Subject: FW: AB/19/21/HH - 32 Maltravers Street Arundel - Request for Update on Planning Application

We write with reference to planning application **AB/19/21/HH (32 Maltravers Street, Arundel, BN18 9BU)** that was submitted online on 19 February 2021 on our behalf by our agent John Wheatley of John Wheatley Architecture.

PL01 Rev A - Location Plan 1250
PL02 Rev B - Block Plan 500 - (this includes the dimensions requested)
PL03 Rev B - Existing and Proposed Site and Roof Plans 100
PL04 Rev E - Existing and Proposed Ground Floor Plans 100 - (this also includes the dimensions requested although not essential to the application)
PL05 RevB - Existing Elevations and Sections to Rear Single Storey Extension 100
PL06 Rev D - Proposed Elevations and Sections through Rear Extension 100

project: 32 Maltravers Street - Arundel - BN18 9BU			
drawing title: Existing & Proposed Ground Floor Plans			
drawing status: Planning Application Proposals			
date: 01 - 03 - 2021	scale at A3 original size 1:100	no: JW2012ARU - PL04	rev: E

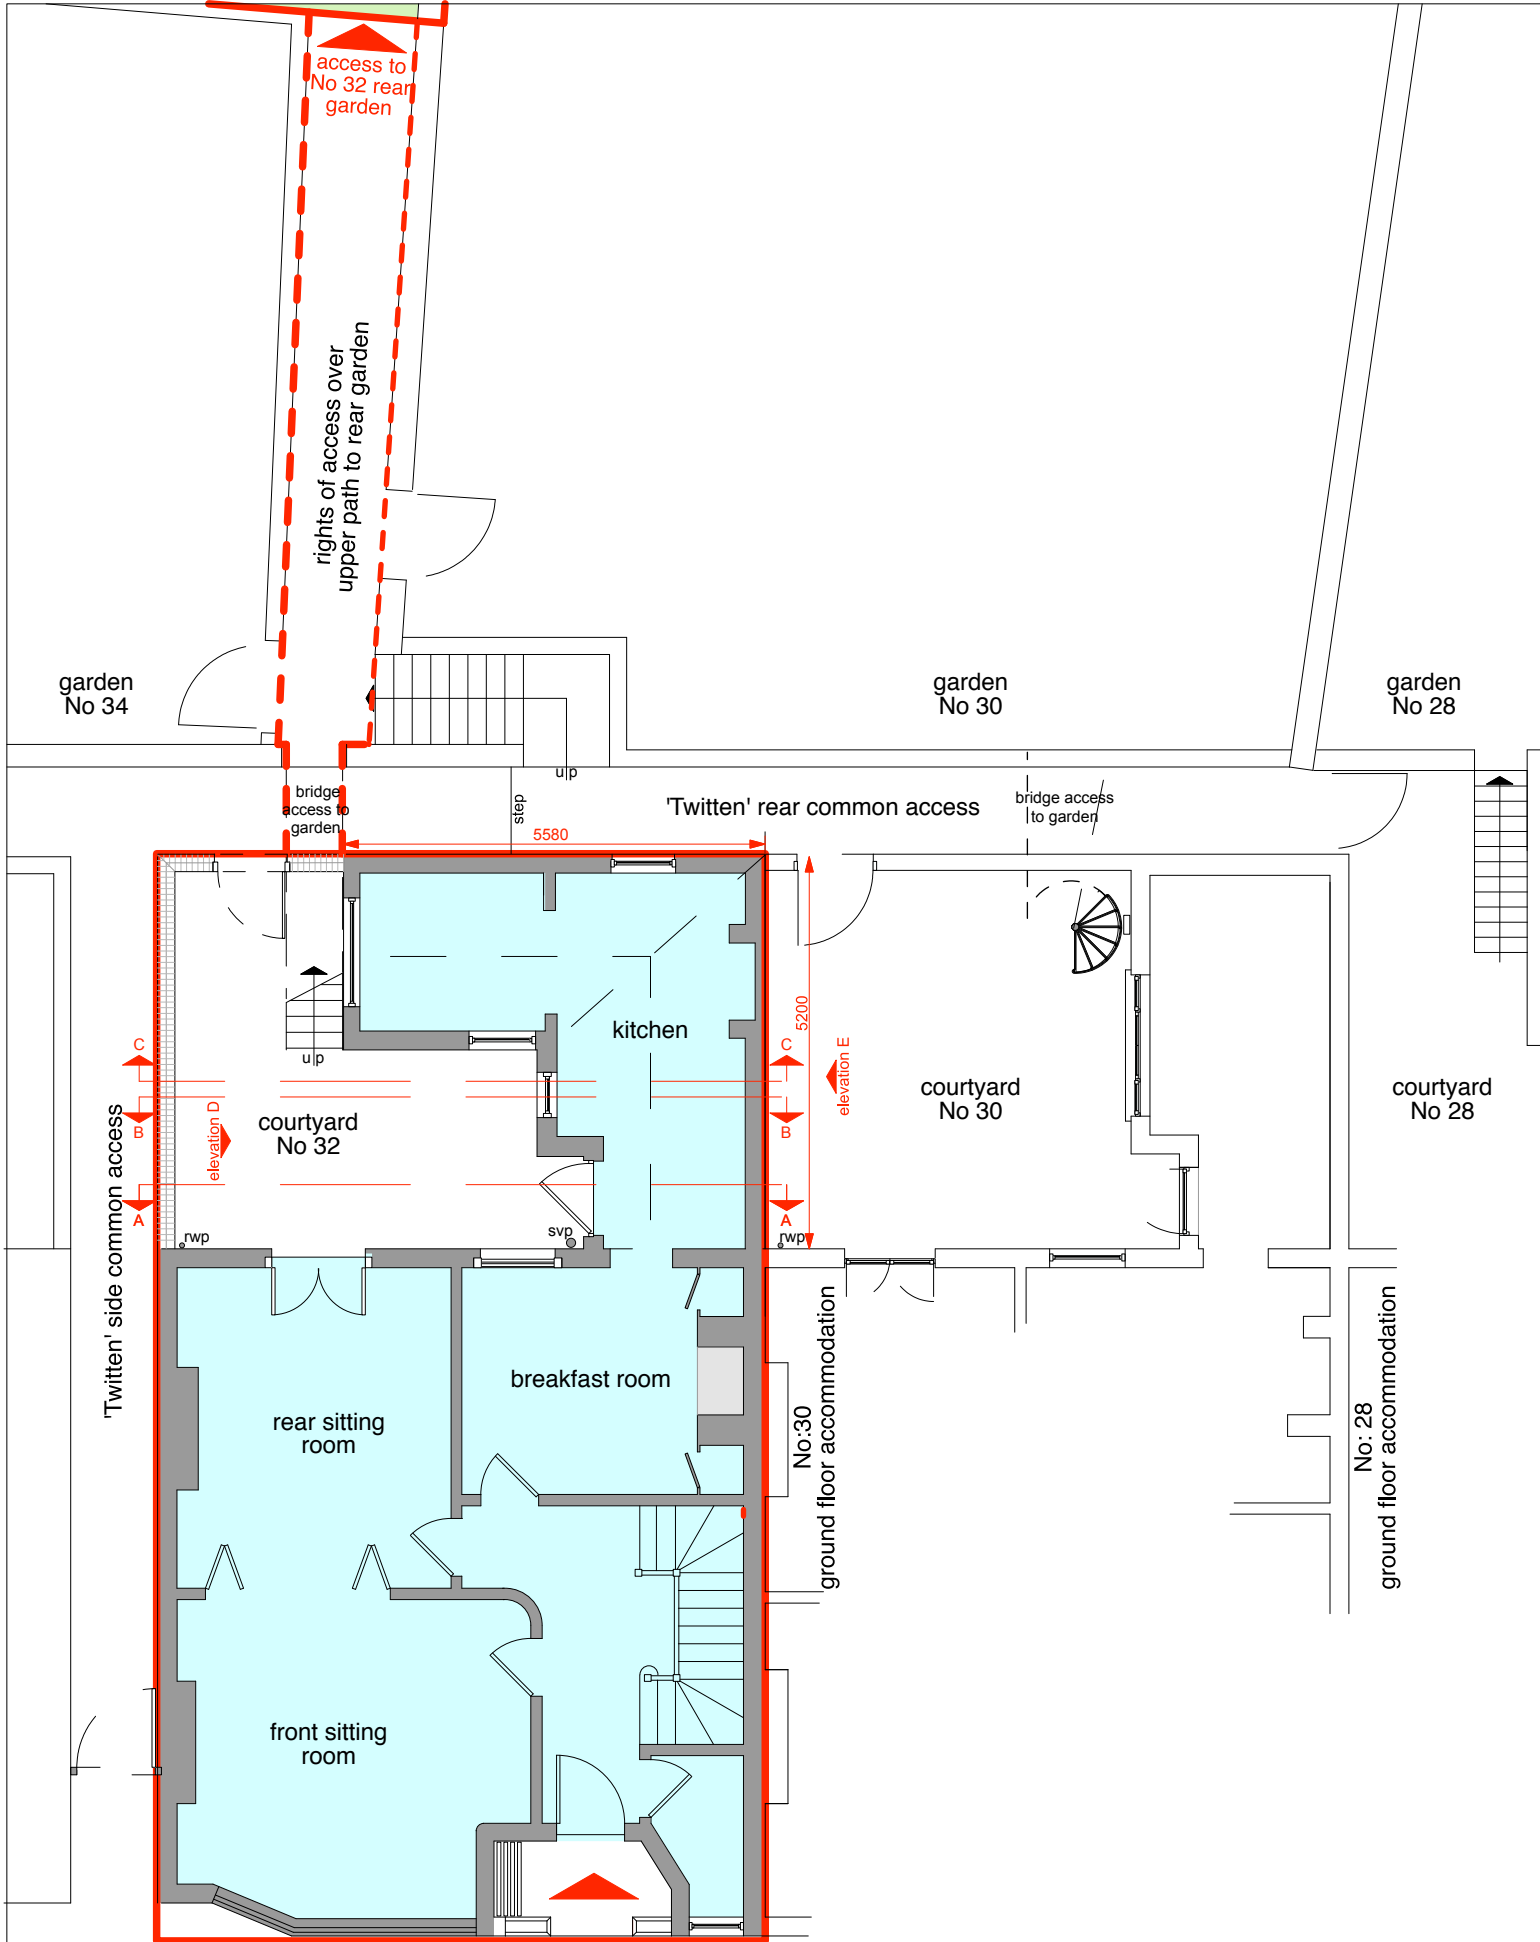
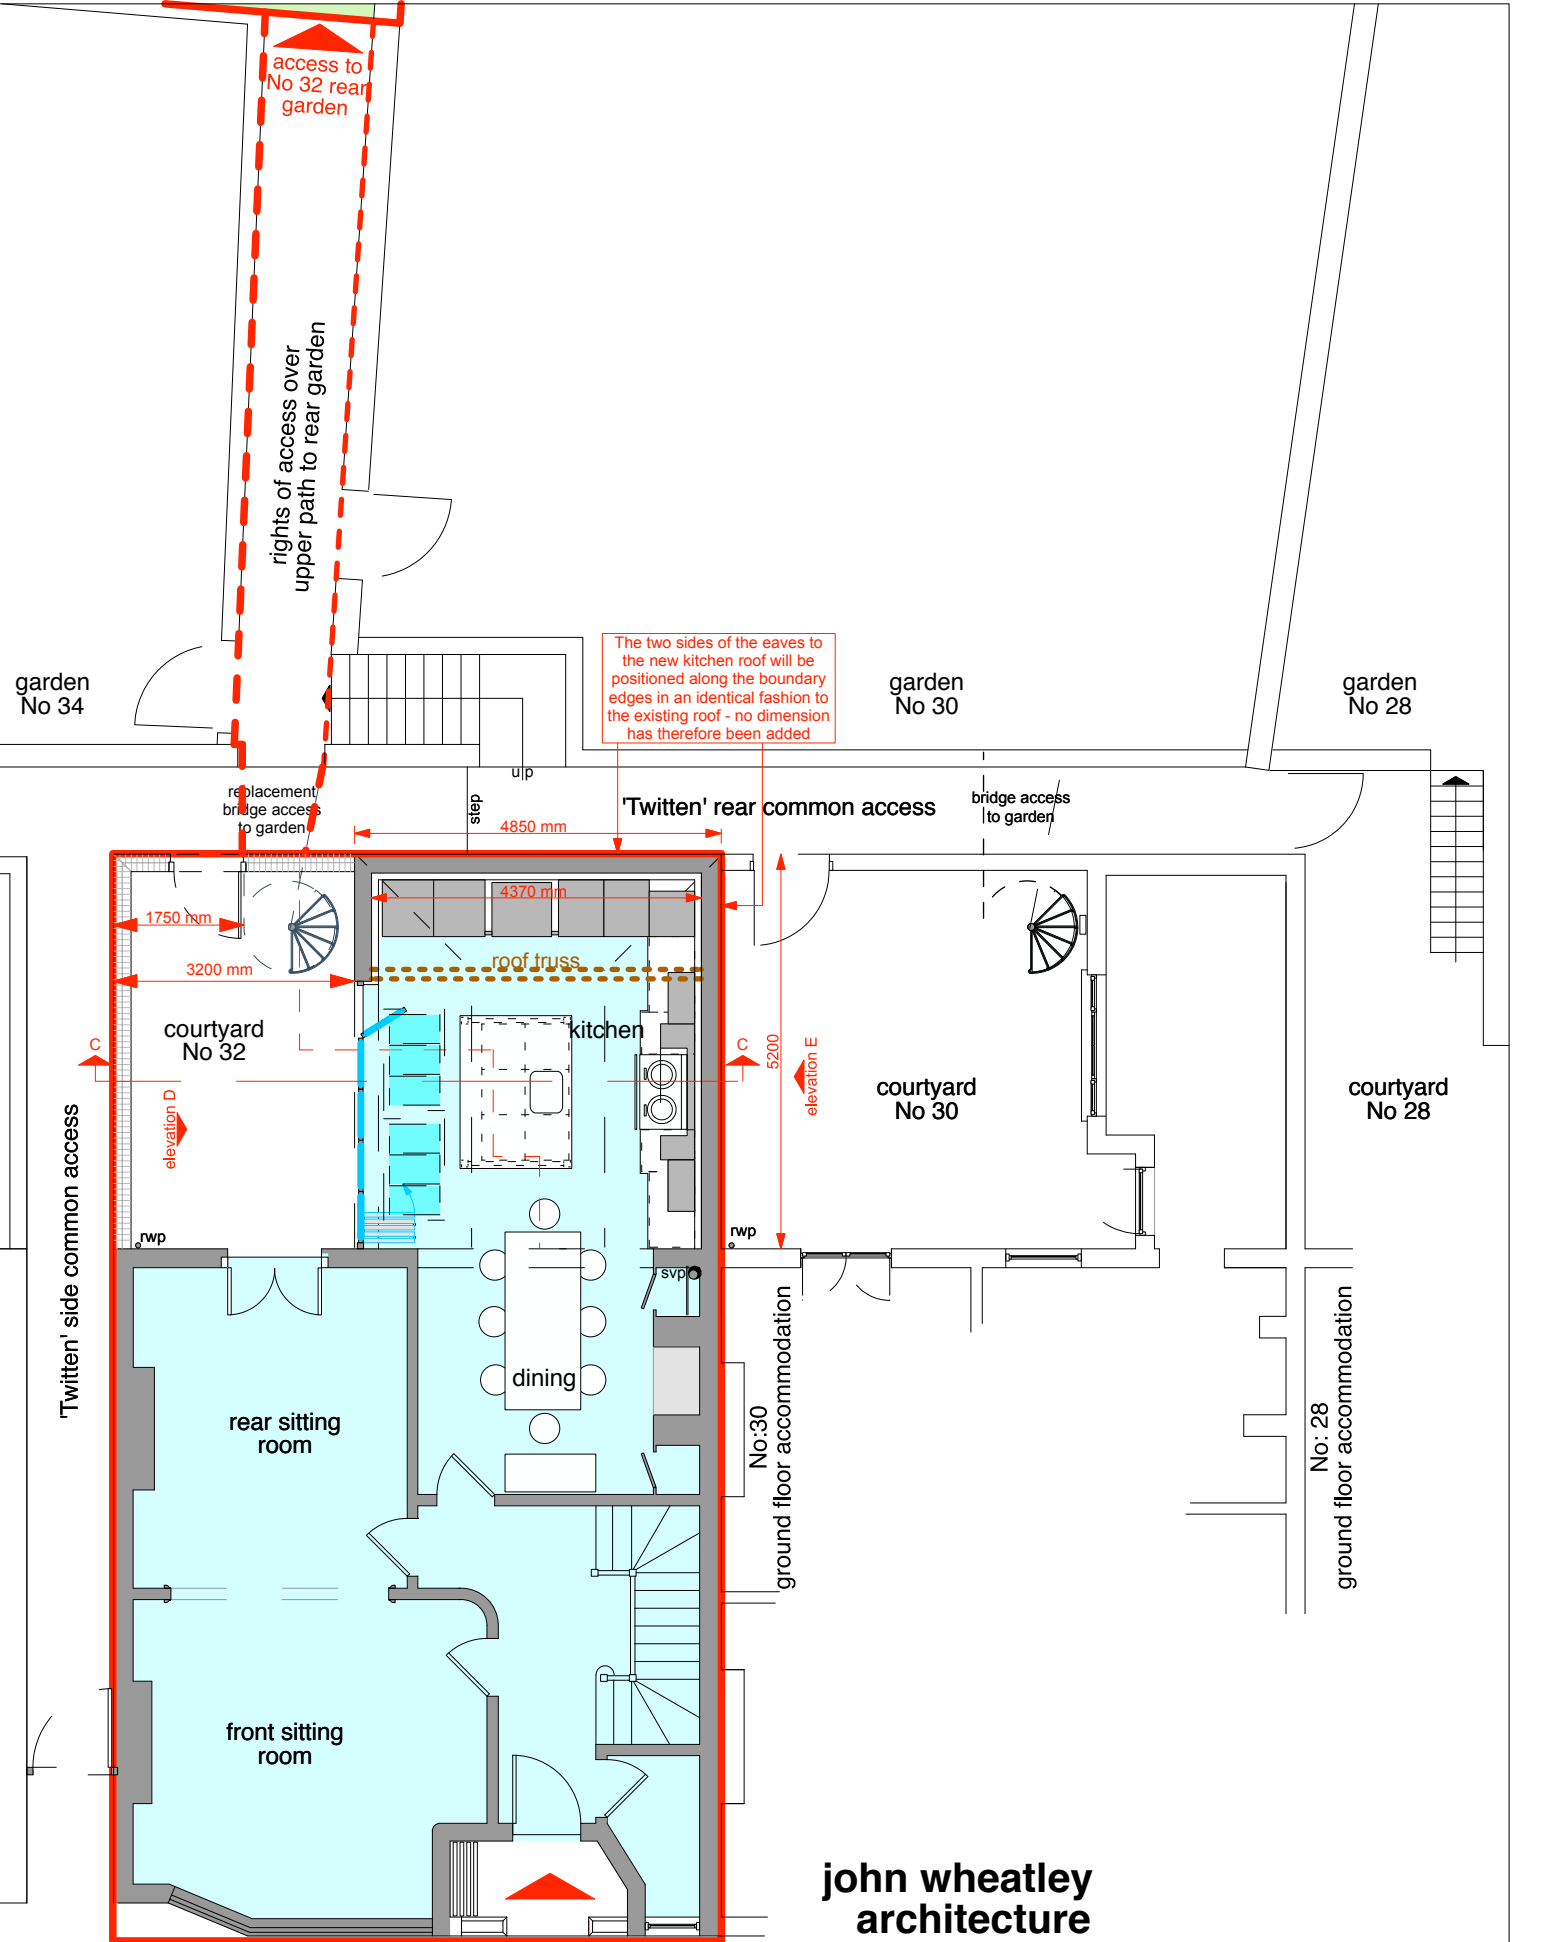
- Dimensions: You are required to include dimensions from the proposed extensions to all site boundaries. Apologies for this omission - I have now added dimensions to the courtyard on the Proposed Ground Floor Plan on a now later revision of PL04.

**Development at 32 Maltravers Street Arundel BN18 9BU
PL01B - Location Plan at 1:1250 scale (A4)**

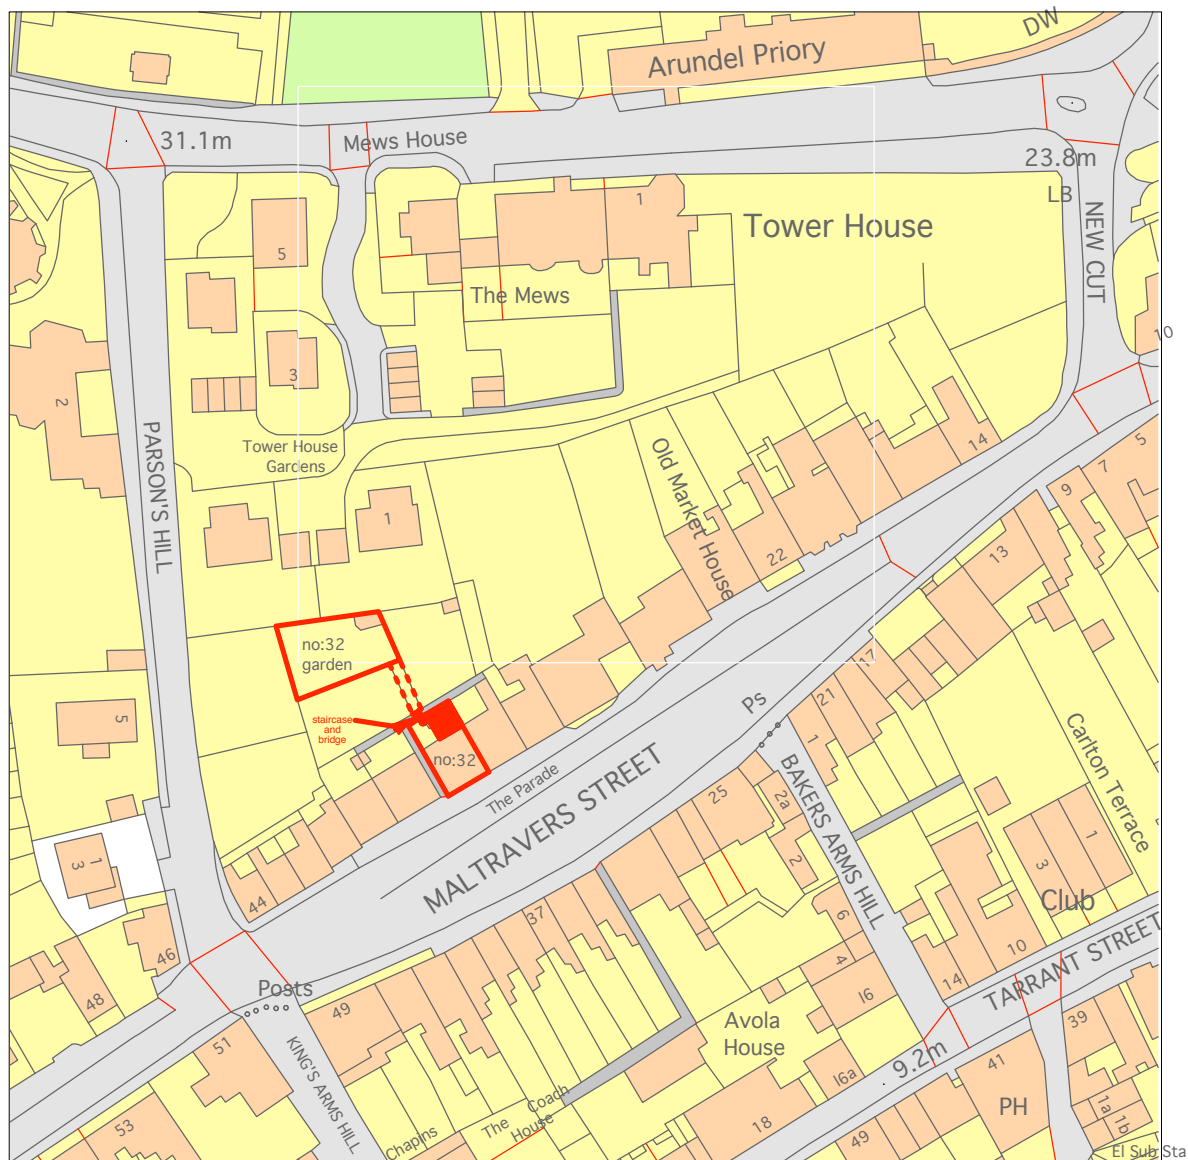
- Location Plan: You are required to only include the proposed site in the red outline on the location plan. Please remove all other red outlines. I was aware that the red line boundary has to be added to the Location Plan, but thought that inclusion on other plans was optional. I typically keep the red lines on all boundaries, so that the context is maintained between different scale plans and have not removed this information therefore as yet. If however you feel it is not possible to register the plans without the redline being removed on PL02, PL03 and PL04, I will reissue them immediately.
